October 21, 1997

RE: REVISED CONCEPTUAL DRAINAGE PLAN FOR BLOCK G ALLWOODS
SUBDIVISION (F17-D70) REVISION DATED 9/30/97

RE: Conceptual Drainage Plan for Block G Allwoods Subdivision (F17-D70)

RE: CONCEPTUAL DRAINAGE PLAN FOR BLOCK G ALL WOODS SUBDIVISION
(F17-D70) ENGINEER'S STAMP DATED 8/25/97

BLOCK G ALLWOODS SUBDIVISION CONCEPTUAL GRADING AND DRAINAGE PLAN

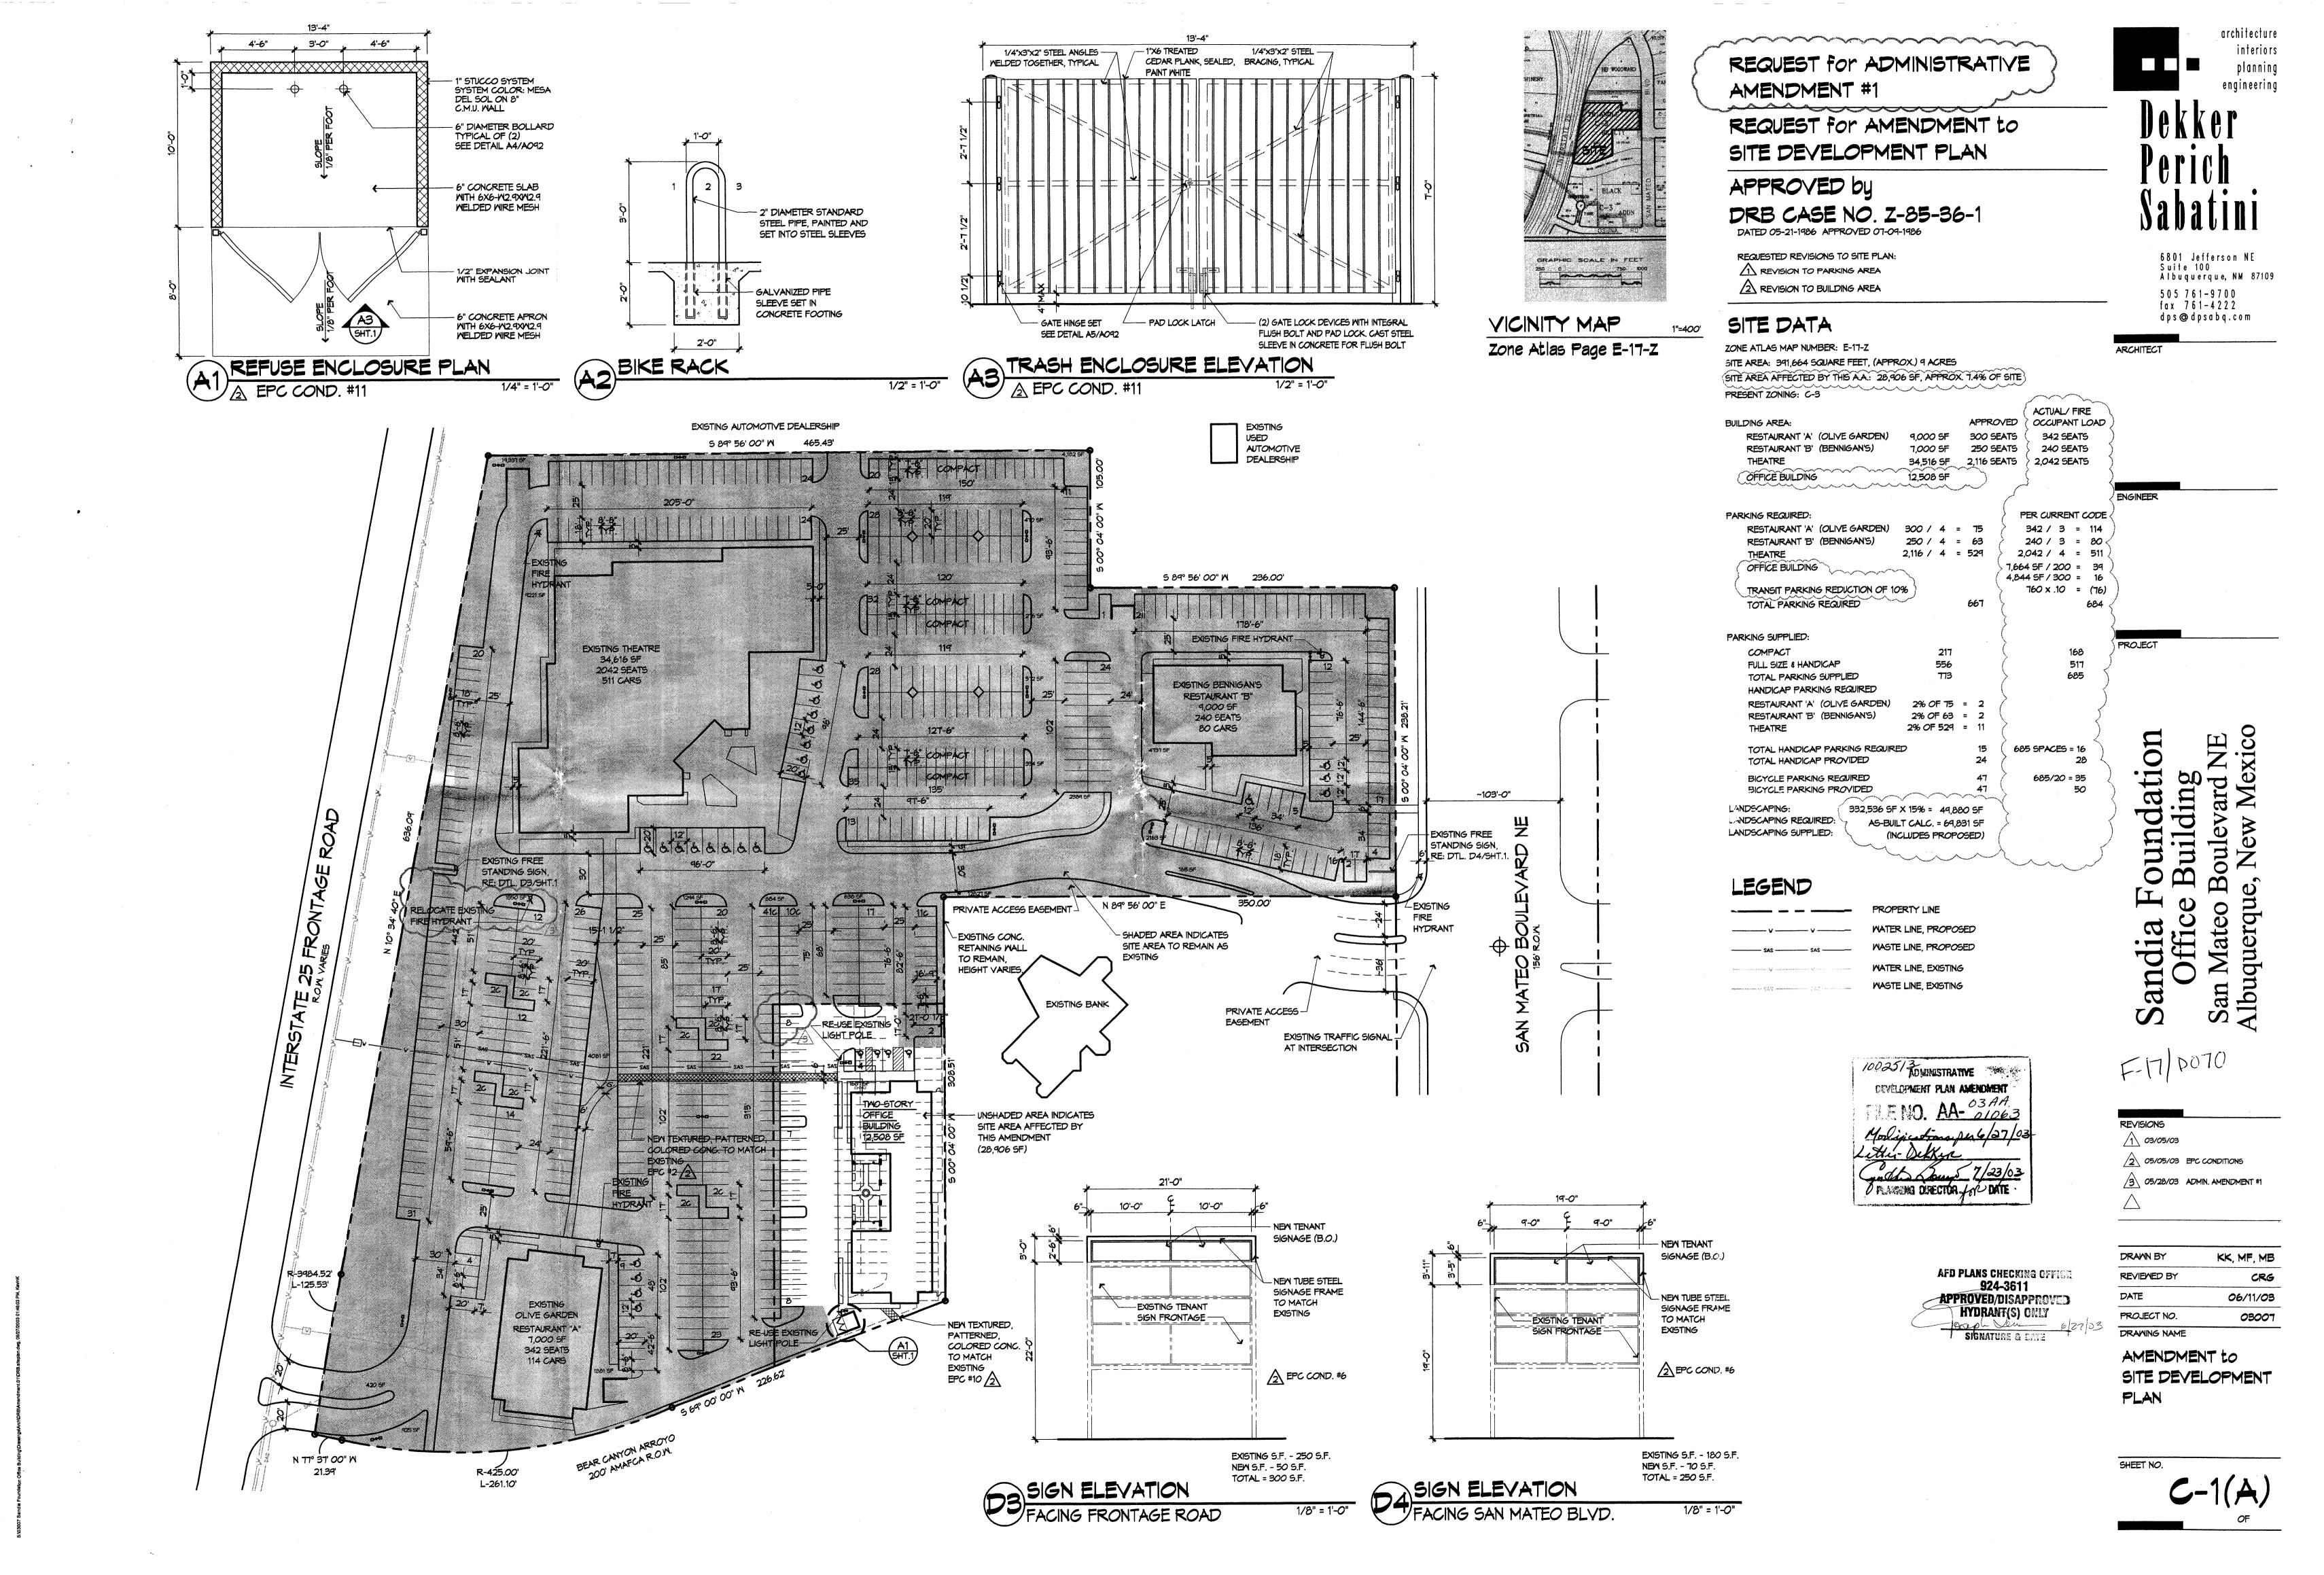
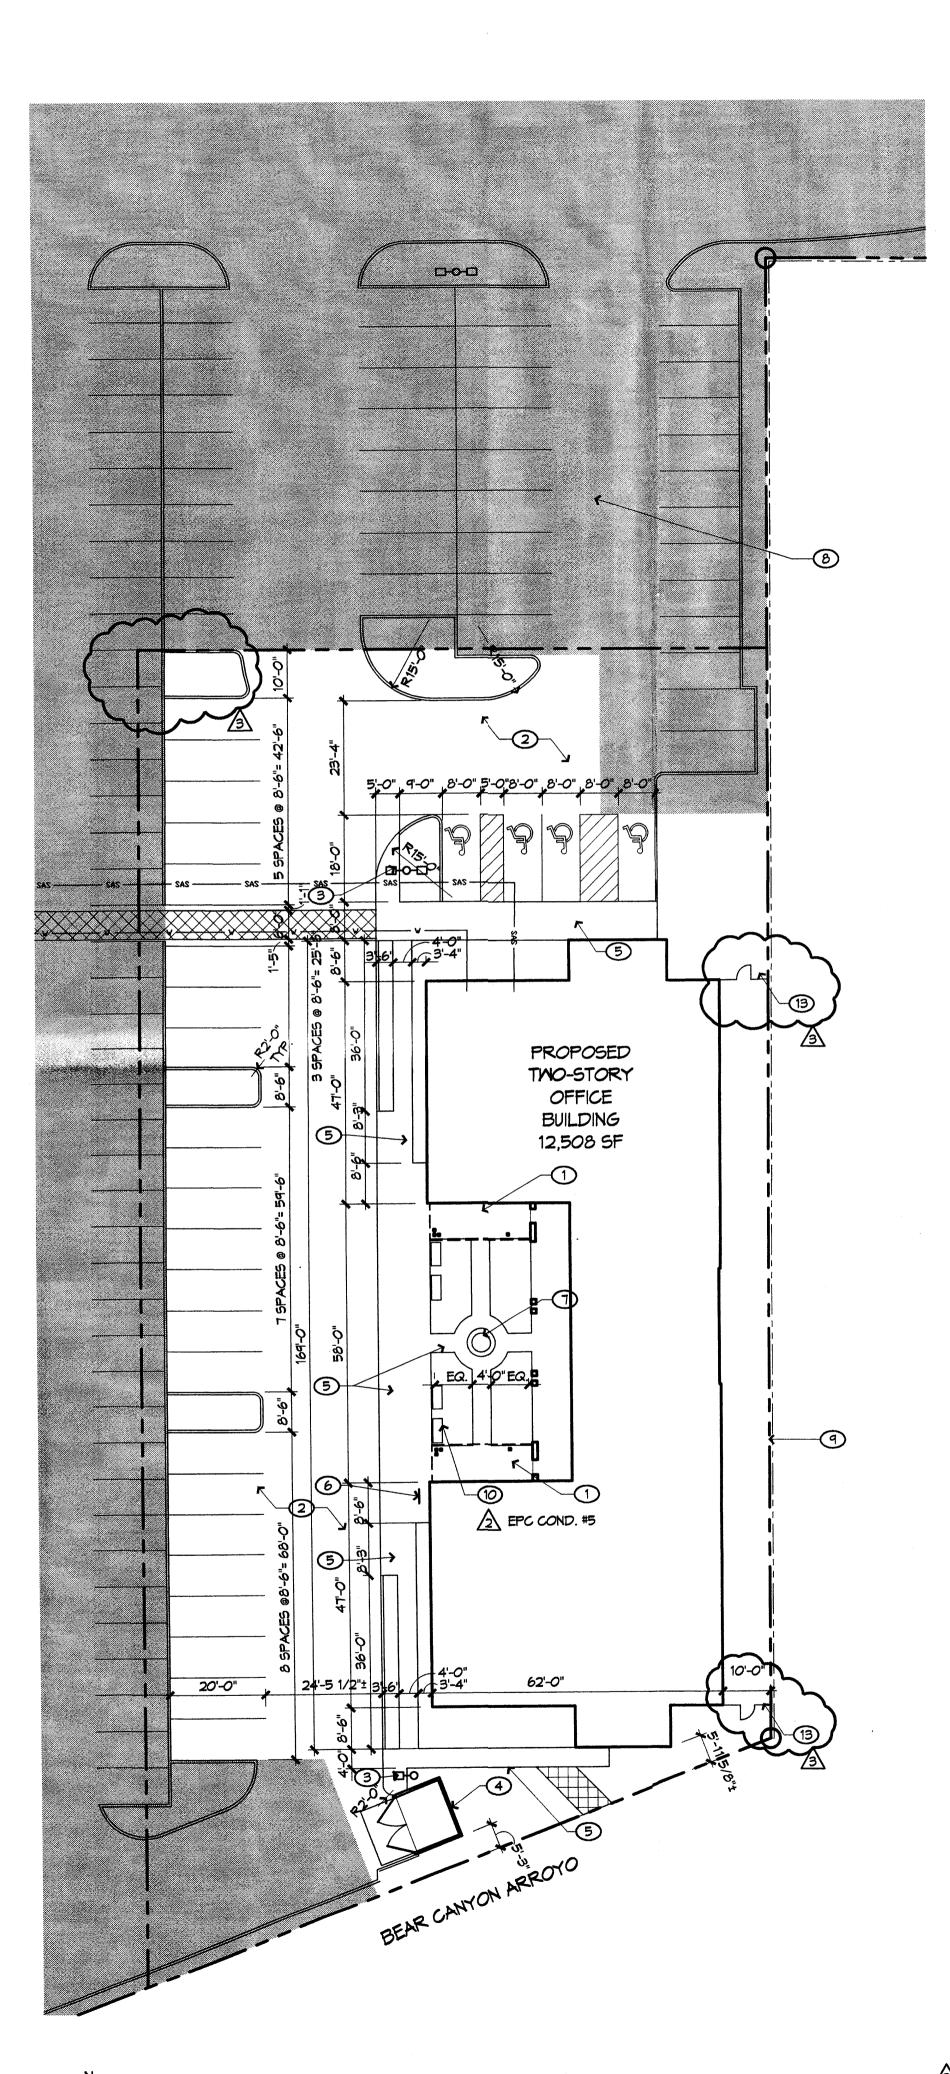
1. Verification of adequacy of downstream systems.
2. Are there any retaining wall requirements on the west & north sides of the property?
3. What is the purpose of the proposed 10' foot drainage and utility easement?
4. If you are proposing mass grading, you will need to provide an erosion control plan. The total site will need to be protected by an erosion control berm.

As you know, there are a number of drainage plans on file at the City that affect or otherwise have some impact on the capacities down stream of this site, both on McLeod Road and Lumber Avenue. First, to address McLeod Road. There are drainage concerns that exist downstream on McLeod where it intersects the Frontage road. As such, it is our opinion that it would be prudent to restrict the discharge from this site to a level not to adversely impact those conditions. Therefore, the plan has been modified to require that the development of this site limit discharge to those calculated as existing. The balance of the runoff created at the time of development would then be directed to the facilities that exist on Lumber Ave.

For purposes of the subject plan we must added the flow from the site to the total flow of 85.5 cfs (more conservative previously calculated flow). Including the excess developed flow from the most northerly lot the total discharge from this site would be 22.0 cfs ($20.3 + 1.7$). This would result in an anticipated flow rate at the western property line of Tract G (subject parcel) of 107.5 cfs. Further, based on field data obtained last month, a cross section of Lumber Ave. at this location has a capacity of approximately 118 cfs contained within the curb. (see plan for location and calculations)

In summary, the discharge flow rate to McLeod will be limited to that calculated as existing. The flows to Lumber Ave. of approximately 107.1 cfs can be contained within the existing road section and can be accepted by the existing inlet.

There are no retaining walls required to achieve the conceptual grading scheme as shown.

The drainage easement proposed across the rear of the property is to allow for the "lot-to-lot" drainage as proposed. The only viable option to drain the interior parcels is through the rear of the adjacent parcels. Future development of the individual parcels shall be required to accept and convey the adjacent flows as shown on the plan.

No grading is proposed at this time. Substantial fill will be required to achieve the grading scheme shown which shall be accomplished at the time the site develops.
